About the application

Application number: 2023/91280	
What is the application for?:	Quarrying operations for the extraction of clay, shale and incidental coal and s
Address of the site or building:	Bromley Farm Quarry, Barnsley Road, Upper Cumberworth, Huddersfield, HD8 8PD
Postcode:	S36 4HG

HGV ROUTING PLAN

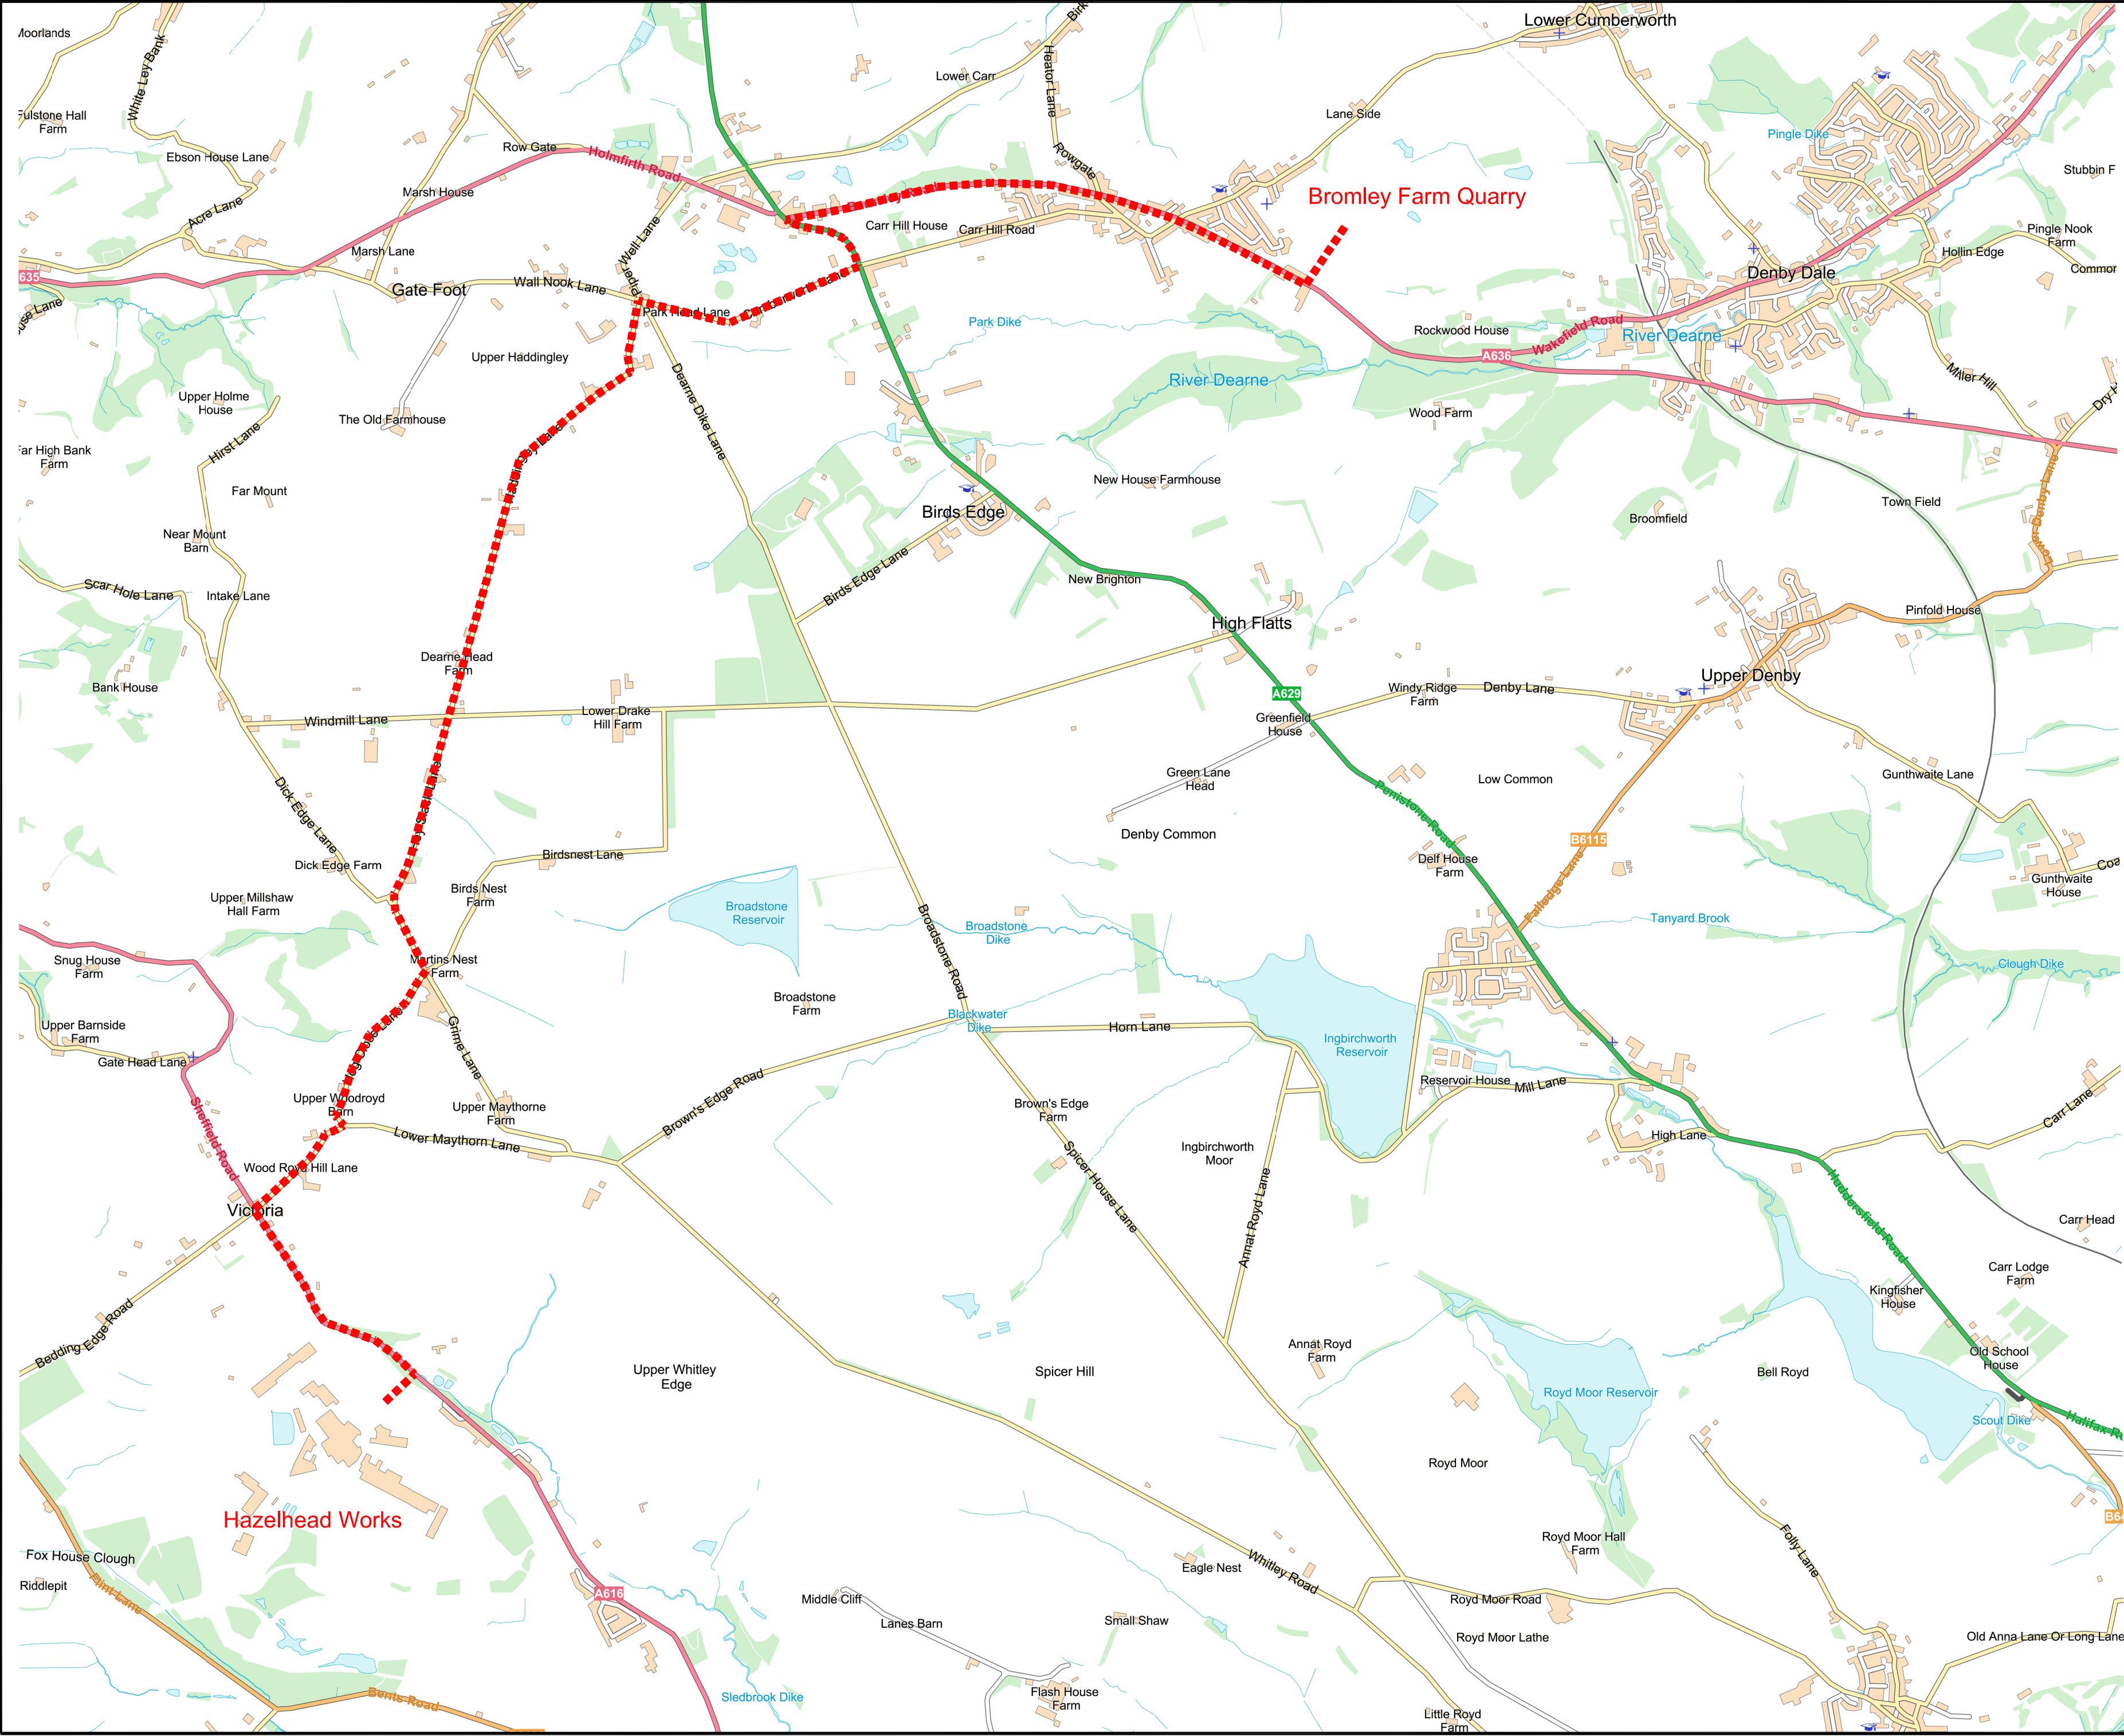
Type of comment: An objection	
Do you wish your comments to be published on the website anonymously?	Yes
The impact of the development on the transport network in terms of highway safety should be mitigated by traffic regulation to route traffic away from the residential areas of Park Lane, The Croft, Carr Green, Carr Mount, Wells Mount, Carr Cottages and various other small developments which are served by Carr Hill Road which is the estate distributor road for the area of Upper Cumberworth situated to the south side of the A635 Barnsley Road. This could be easily achieved by extending the existing 3.5 ton weight limit already in force on Carr Hill Road between the A629 and A635 roads (down Carr Hill Road) to cover vehicles travelling in the opposite direction from the A635 to the A629 (up Carr Hill Road). If the proposed development is to be permitted, it would be prudent to impose a condition requiring the developer to route HGV's from the site away from unclassified residential estate roads.
